Your ref:
Our ref: 24/00112/A
Please ask for: Valera Lvov
Direct dial: 01553 616865
E-mail: borough.planning@west-norfolk.gov.uk

Details: **Advertisement application for Spar illuminated fascia signage to two elevations, a Spar wall panel to the right elevation and window graphics to the front elevation. Post office Fascia to front elevation. (RETROSPECTIVE) at Budget Store And Post Office Church Terrace Outwell WISBECH Norfolk**

PROPOSED LHS ELEVATION

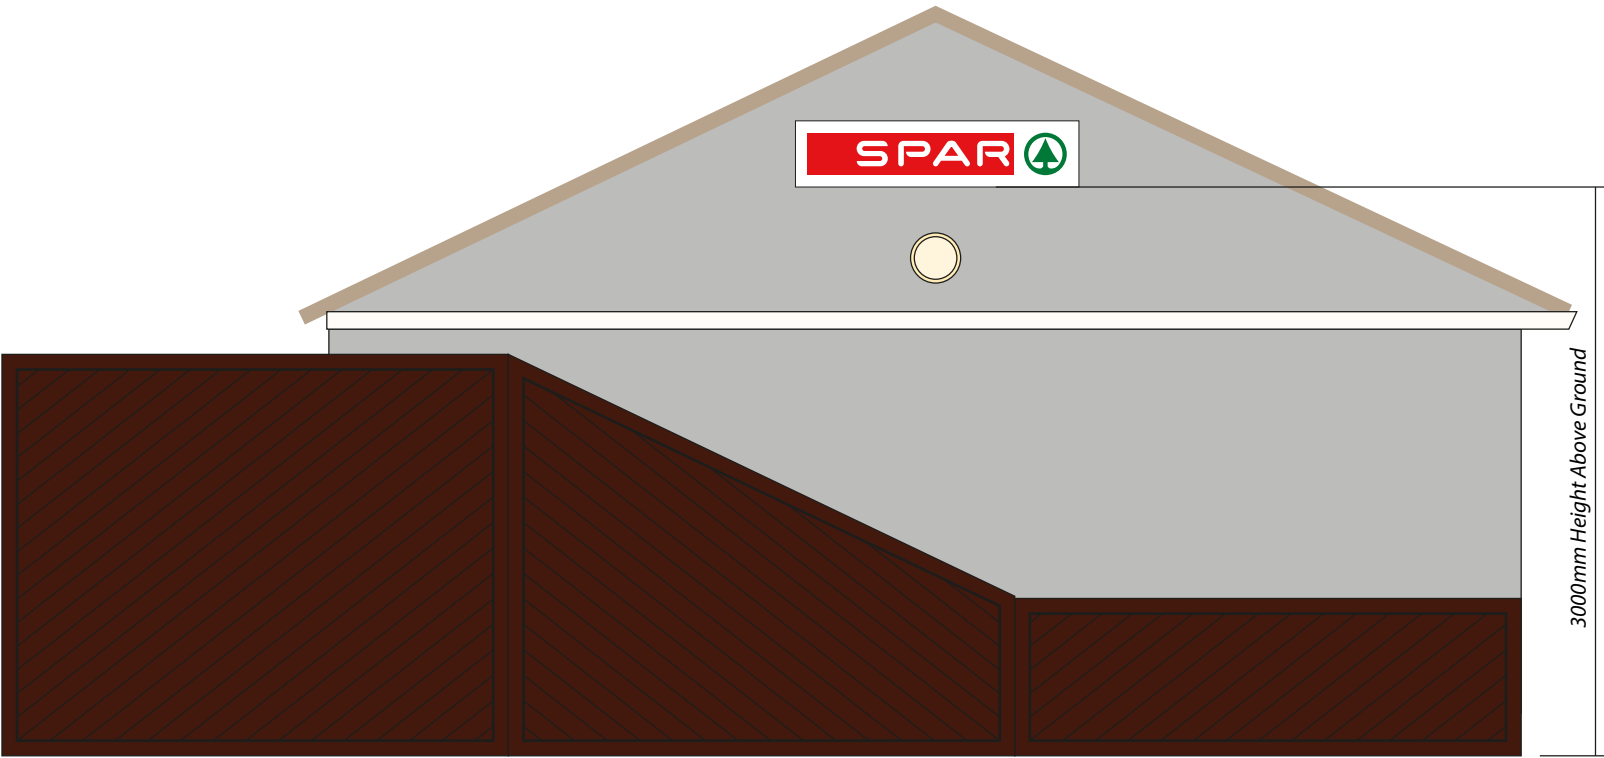
1. Please amend Proposed elevations to a scale of either 1:50 or 1:100
2. Please amend Advertisement drawing(s) at a scale of either 1:50 or 1:100 showing advertisement size, siting, materials and colours to be used, height above ground, extent of projection, details of the method and colour(s) of illumination (if applicable) and sections through
